2.5 EQUIPMENT DEPLOYMENT FALCON HIGH SCHOOL

DN70XC032

9755 TOWER AVE
PEYTON, CO 80831

CONSTRUCTION DRAWINGS

PROJECT VICINITY MAP

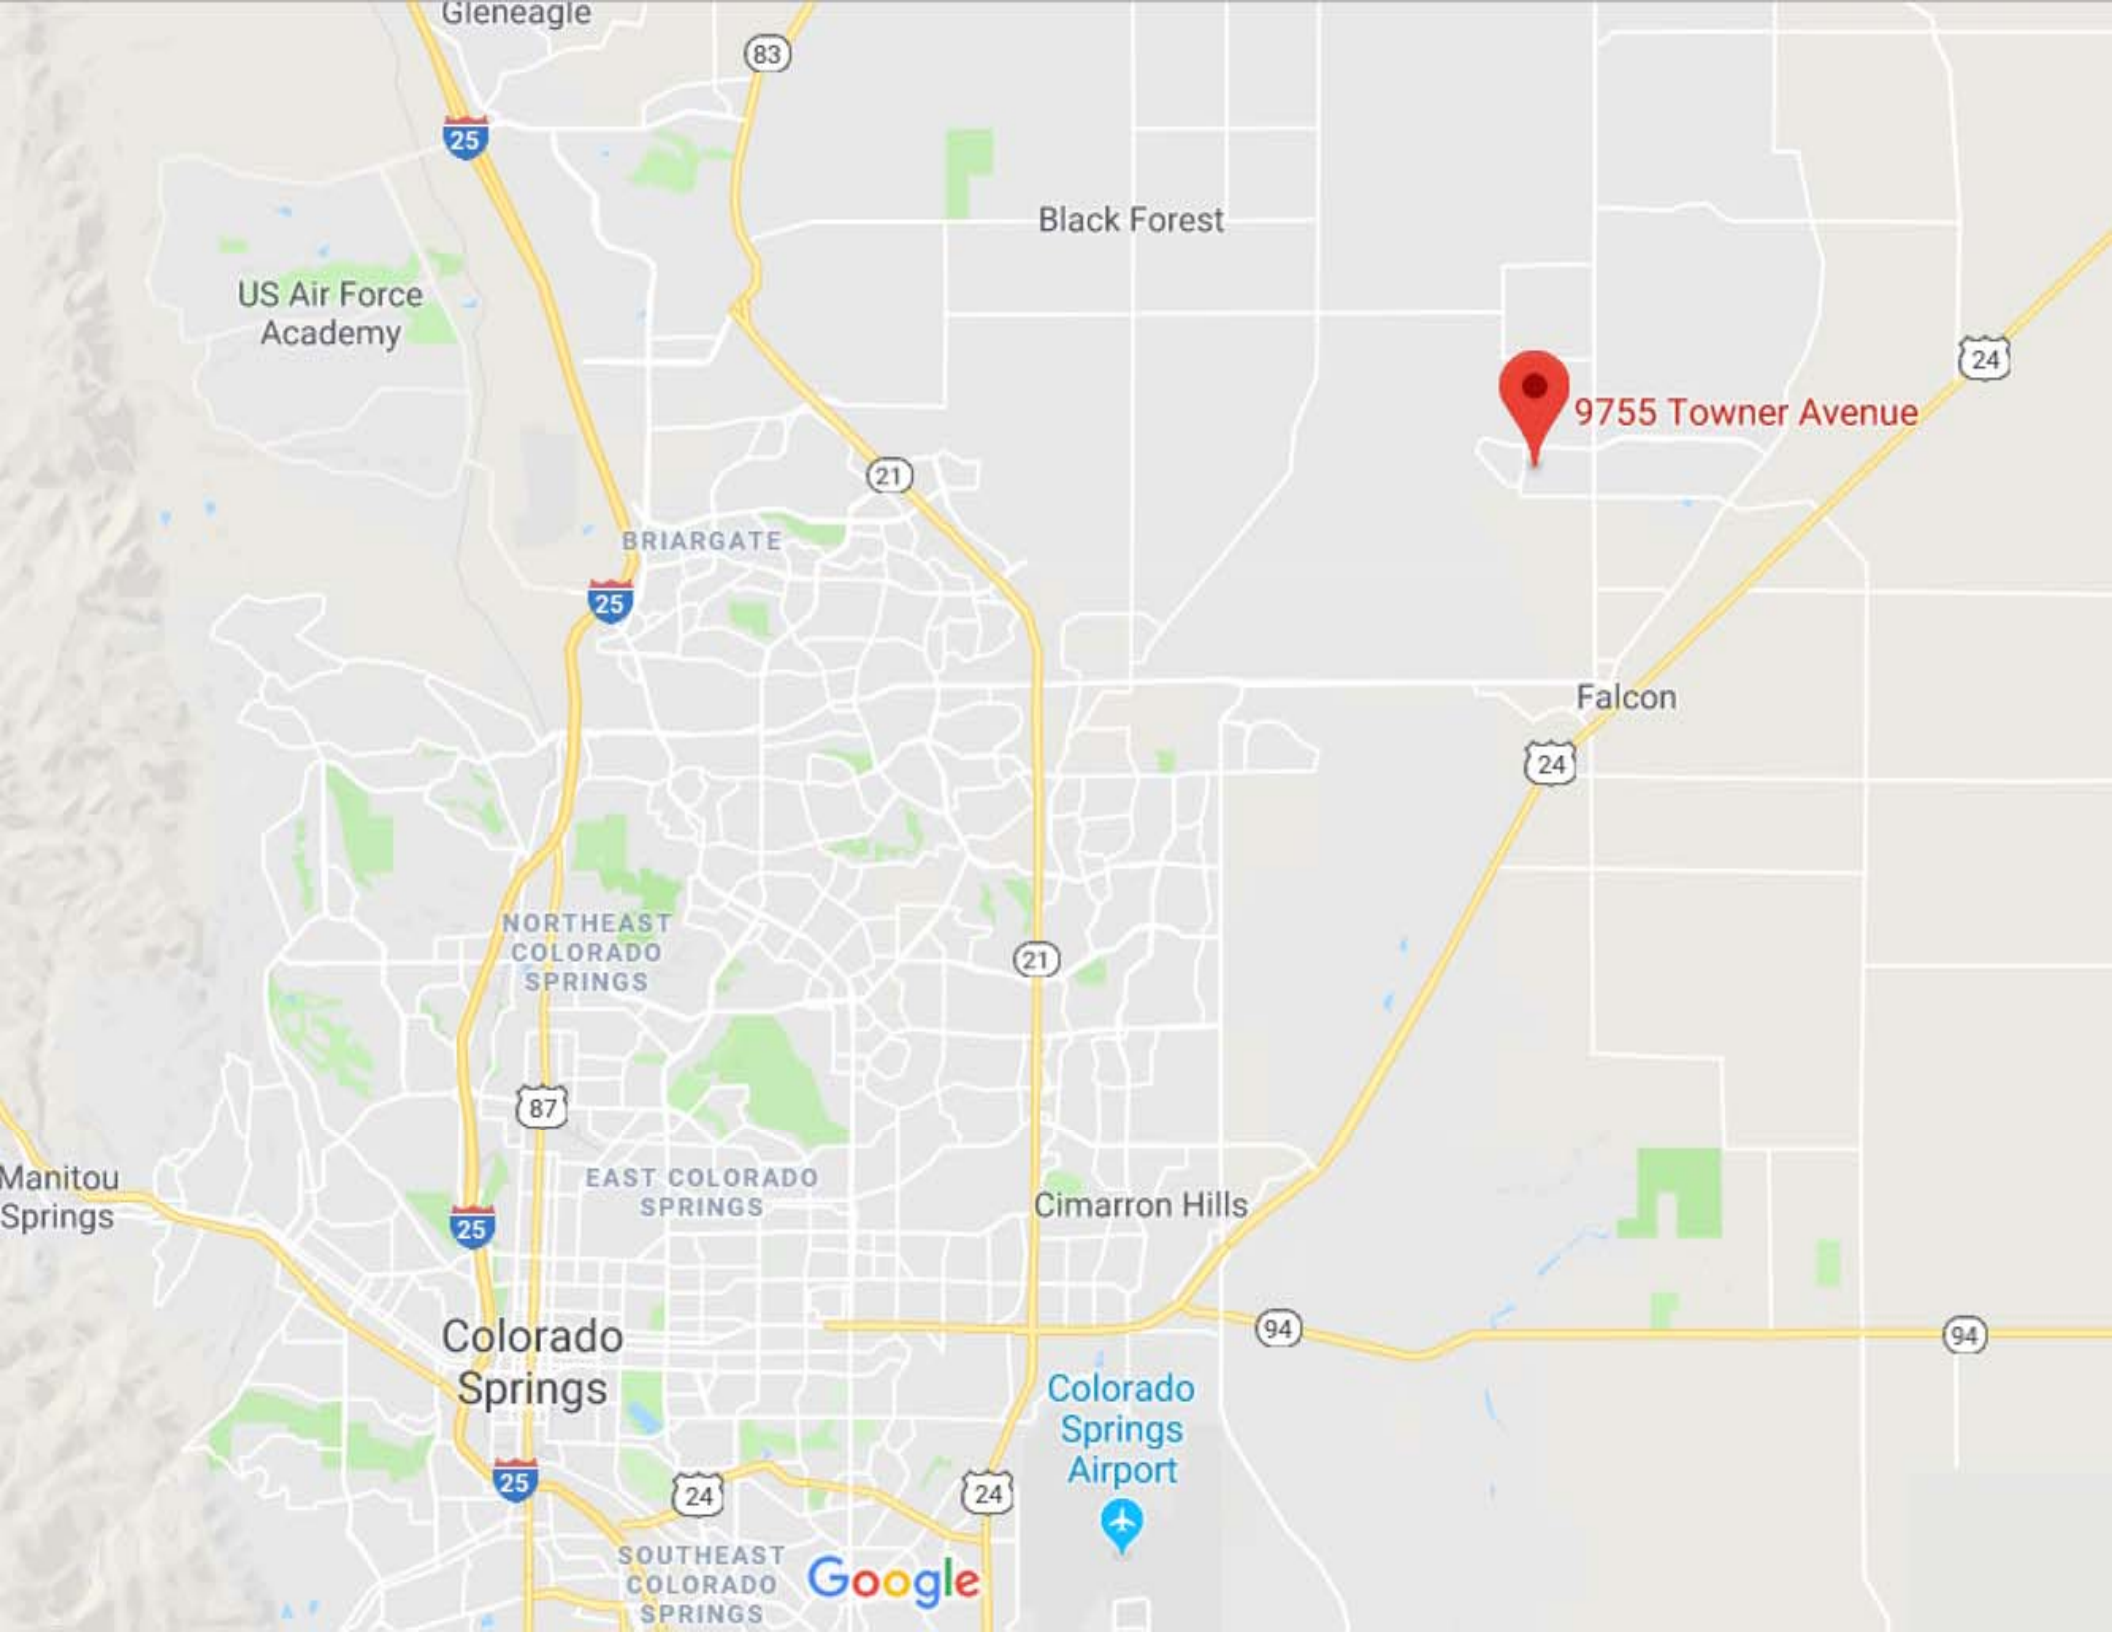
Please provide a better location map so that one can tell exactly where on the site your structures are located, please indicate which are your structures and which are the schools.
